From: Thomas Callaway
Sent: 19 May 2015 13:17
To: Planning.Responses
Subject: RE: Planning Consultation on: AL/34/15/HH

APPLICATION NO: AL/34/15/HH

Site Address: 6 Elmcroft Place Westergate PO20 3XL

Description of Works: Demolition of porch & conservatory & erection of single storey rear/side extension.

proposed roof plan

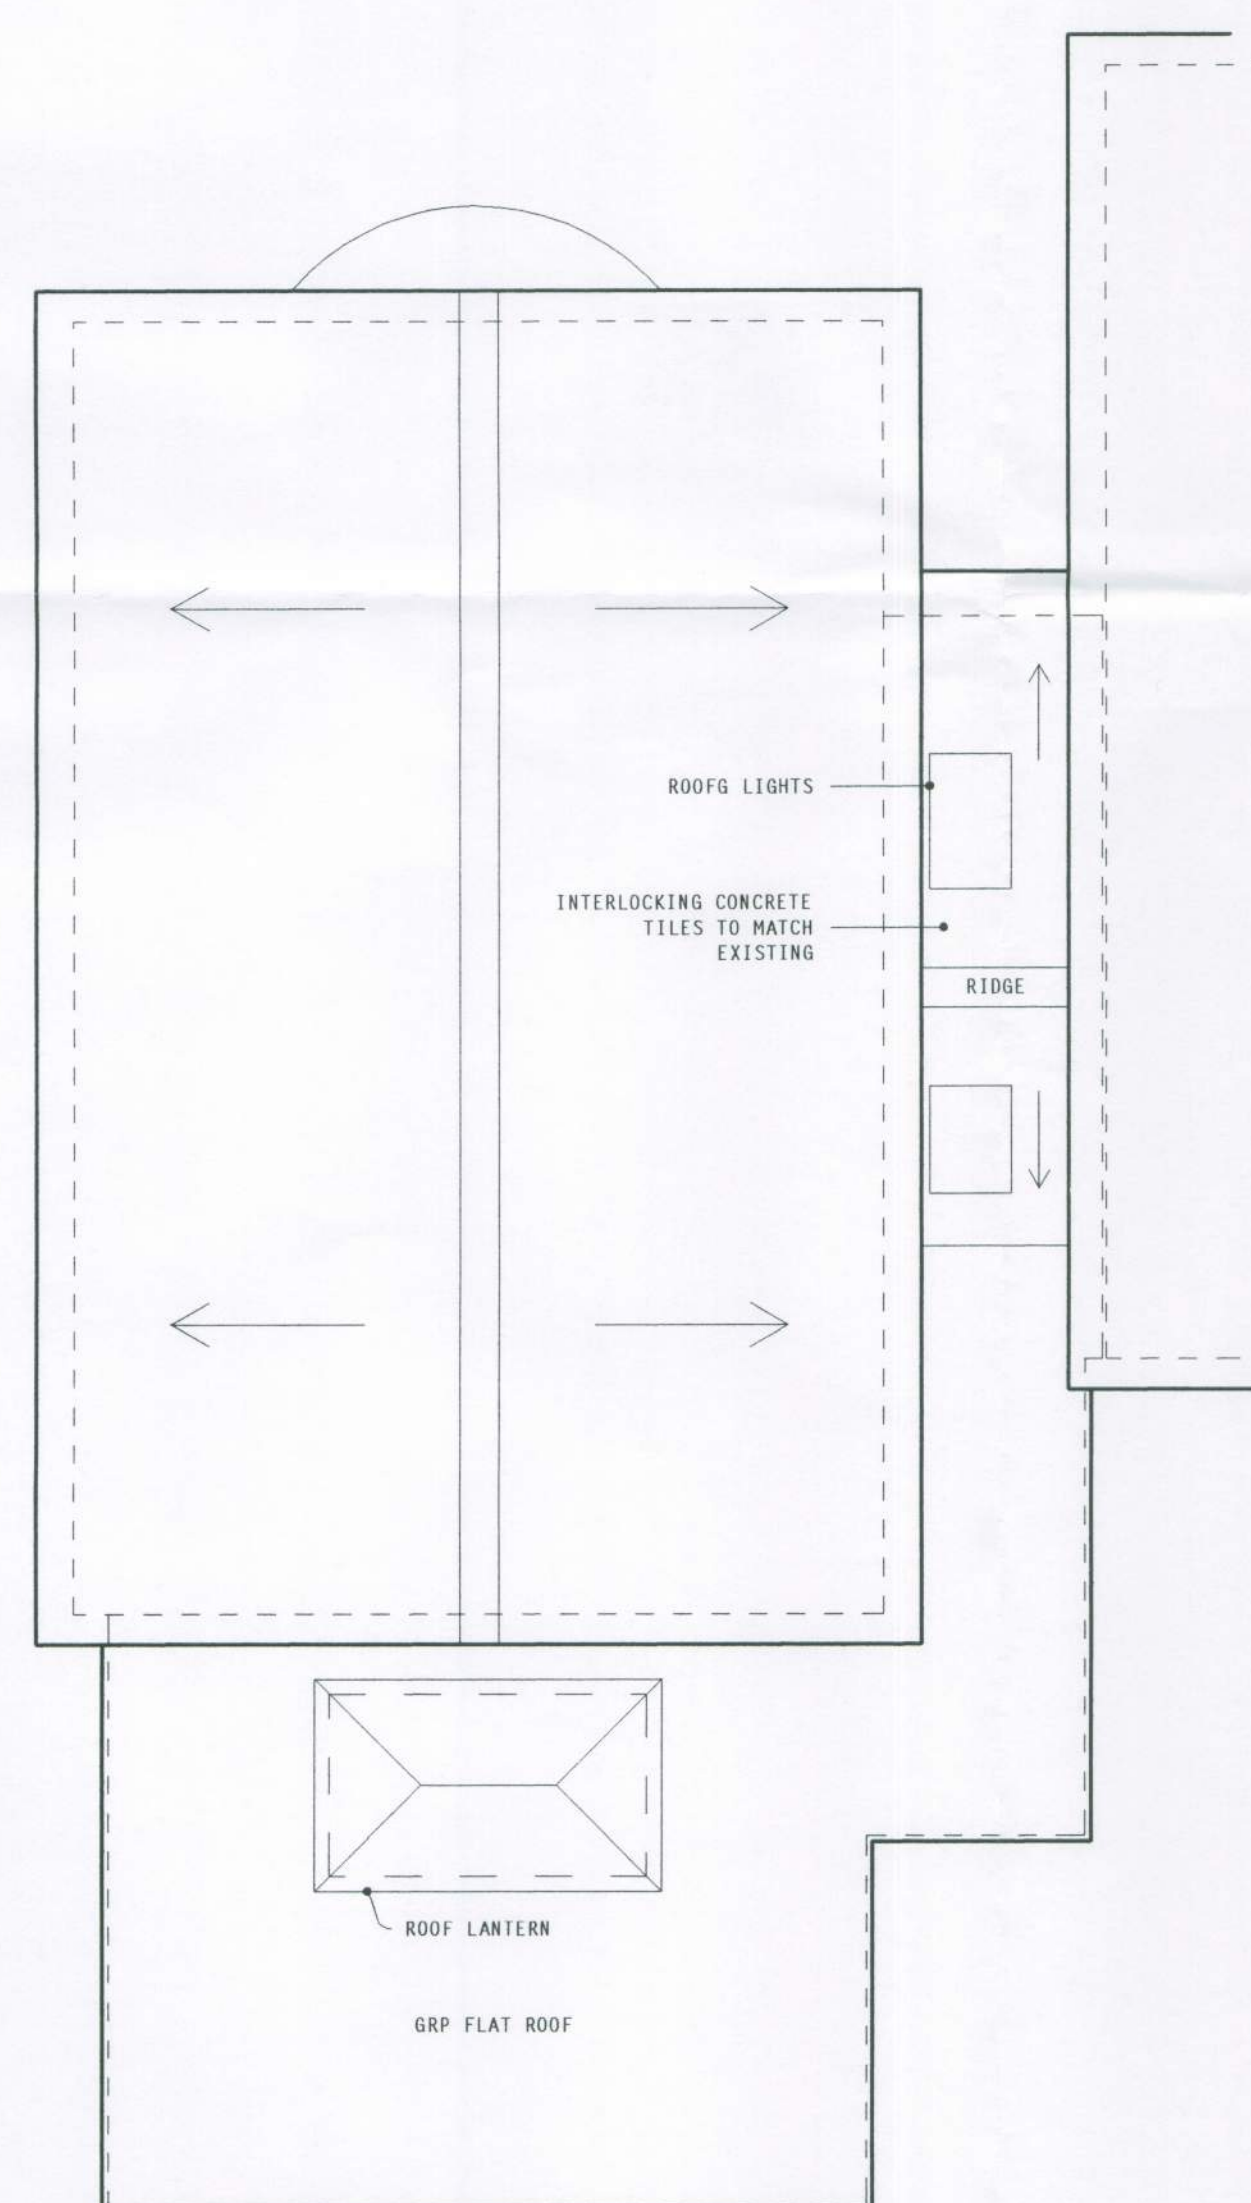
Surface water drainage should be provided for all new roof areas, prioritising infiltration.

Please apply standard conditions ENGD2A.

Infiltration rates for soakage structures are to be based on percolation tests undertaken in the winter period and at the location and depth of the proposed structures. The percolation tests must be carried out in accordance with BRE 365, CIRIA R156 or a similar approved method and cater for the 1 in 10 year storm between the invert of the entry pipe to the soakaway, and the base of the structure. It must also have provision to ensure that there is capacity in the system to contain below ground level the 1 in 100 year event plus 30% on stored volumes, as an allowance for climate change. Adequate freeboard must be provided between the base of the soakaway structure and the highest recorded annual groundwater level identified in that location.

Any SuDS or soakaway design must include adequate groundwater monitoring data to determine the highest winter groundwater table in support of the design. The applicant is advised to discuss the extent of groundwater monitoring with the Council's Engineers. Supplementary guidance notes are also enclosed for information.
